1250.bjh.let

13th June 2022

Arboricultural Assessment
for Wildfowlers, Shore Road, Bosham

PROPOSED TREE PLAN
DRAWING NO. AS696/14
DATE OCTOBER 2021
SCALE 1:500

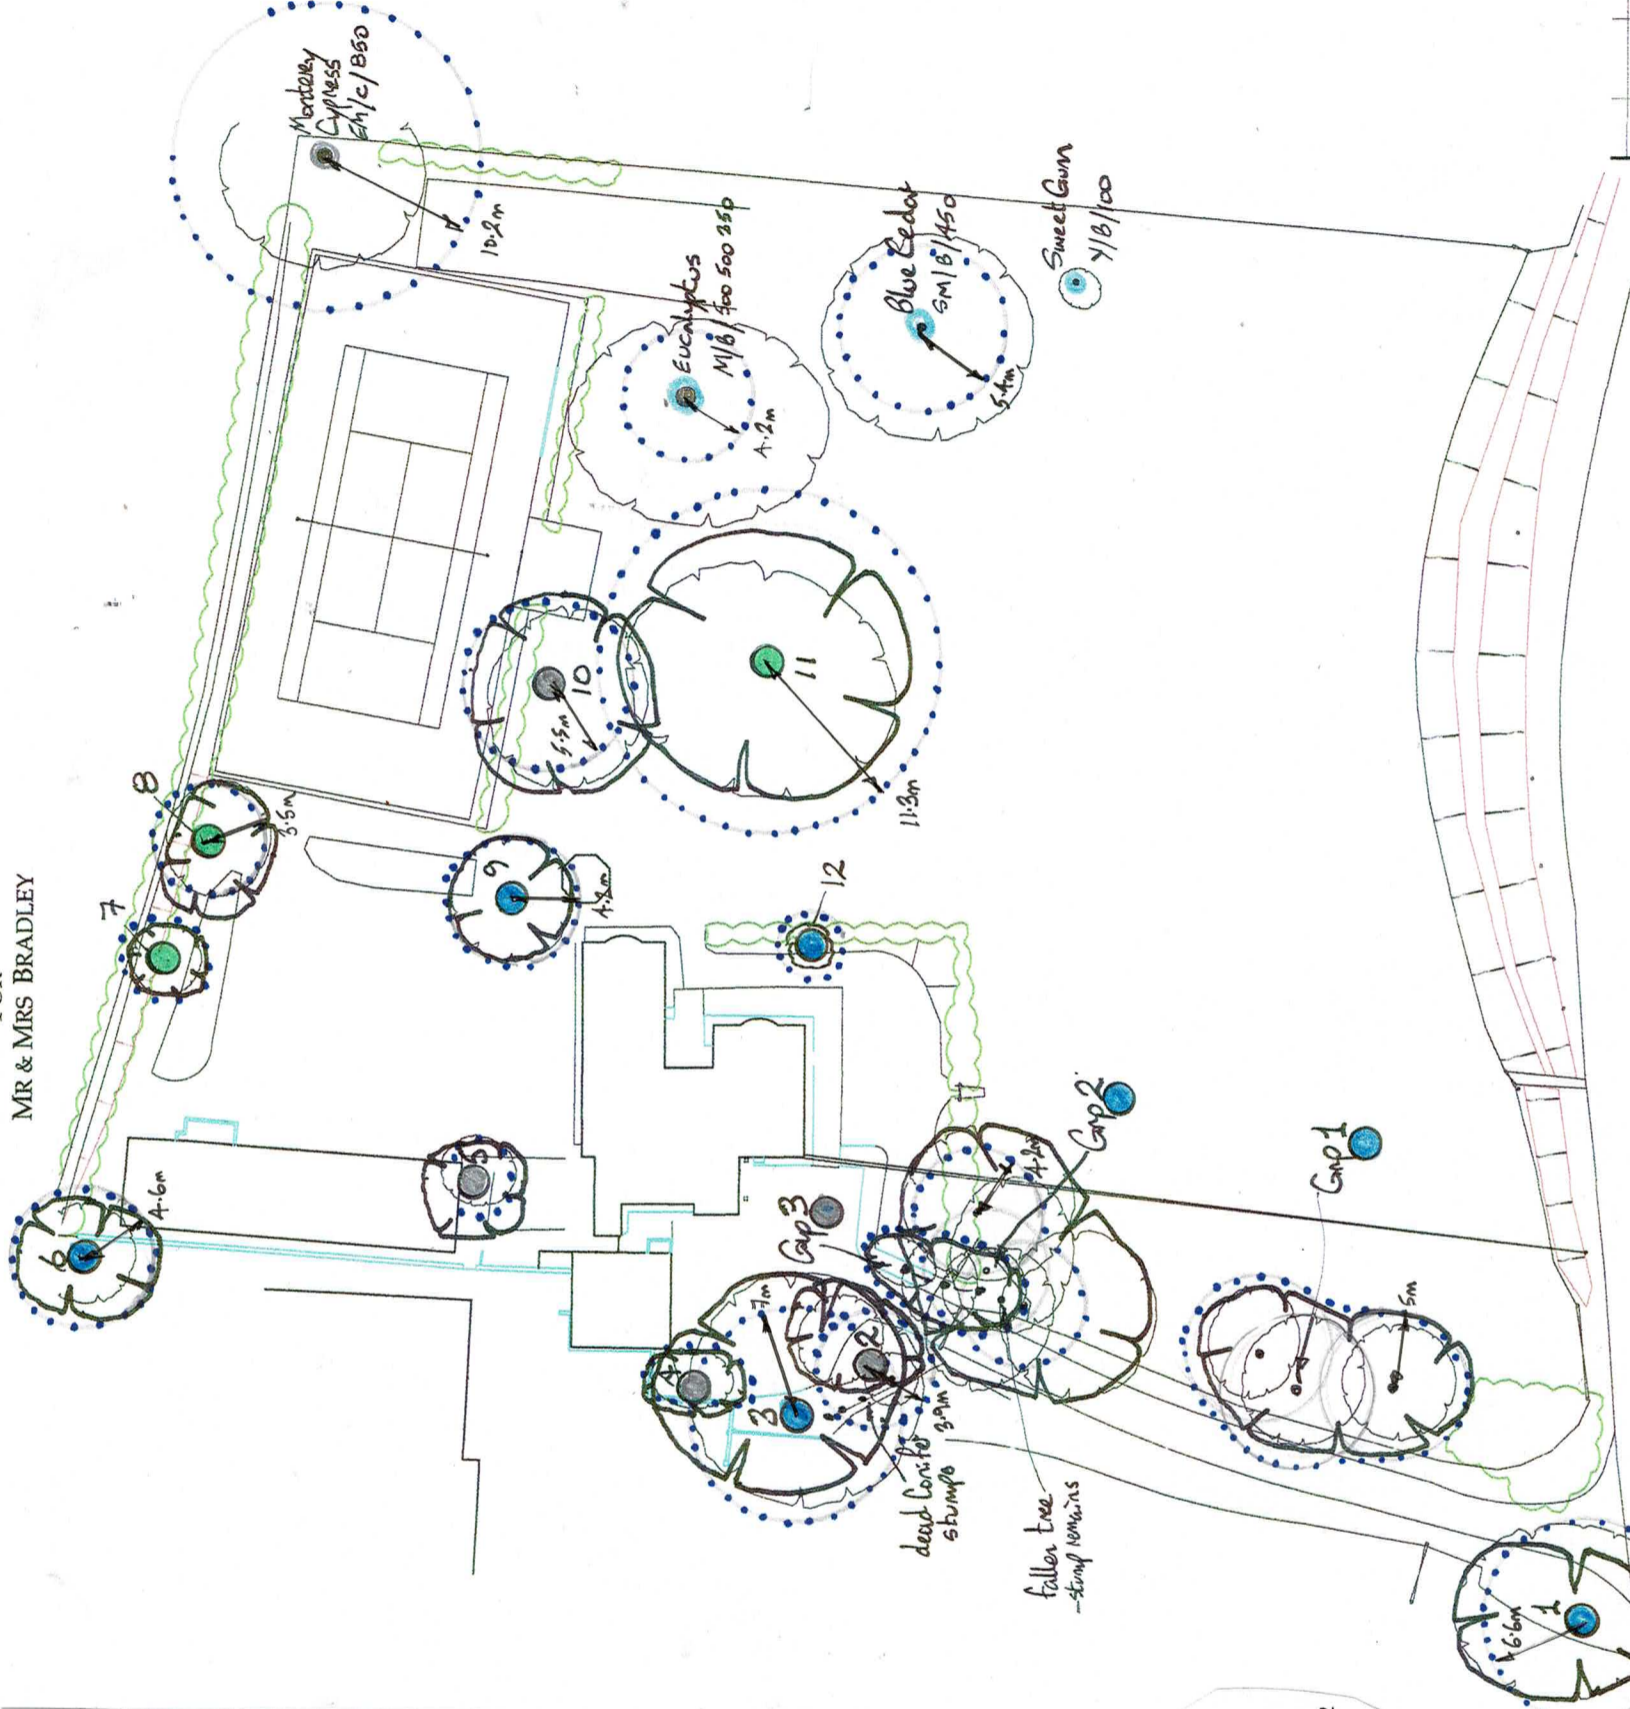
Group 2 Birches – One tree has already fallen/been removed from this group and the remainder are mature trees of moderate B grading but the plans show them to be removed to accommodate the new parking courtyard arrangements. I have no particular preference to see them retained.

Tree 3 Walnut – Shown to be removed to accommodate the revised car parking courtyard. I think this is a shame as this is a good example (moderate B grading) of the species and I would encourage you to review this situation and try to retain this tree if at all possible.

Tree 7 Tulip Tree – Whilst we could in theory retain this tree it has the potential to be a large specimen of at least 20m height with 10m radial spread so does not sit well here if we are trying to retain it. It could possibly be transplanted but I feel that the cost of this would be better spent in planting a new tree on the front lawn or alternatively along the rear boundary behind the Tennis Court.

Tree 8 Foxglove Tree – A fine tree of high amenity value and high A grading – as shame to put it under pressure from the Swimming Pool? Can we not move the Pool at least 1m northwards as tree 9 is going?

Tree 11 Sweet Chestnut – A really good tree of high amenity value and A grading that merits retention and protection. The new patio area will impinge into its RPA so mitigation measures will need to be applied to protect its root system.
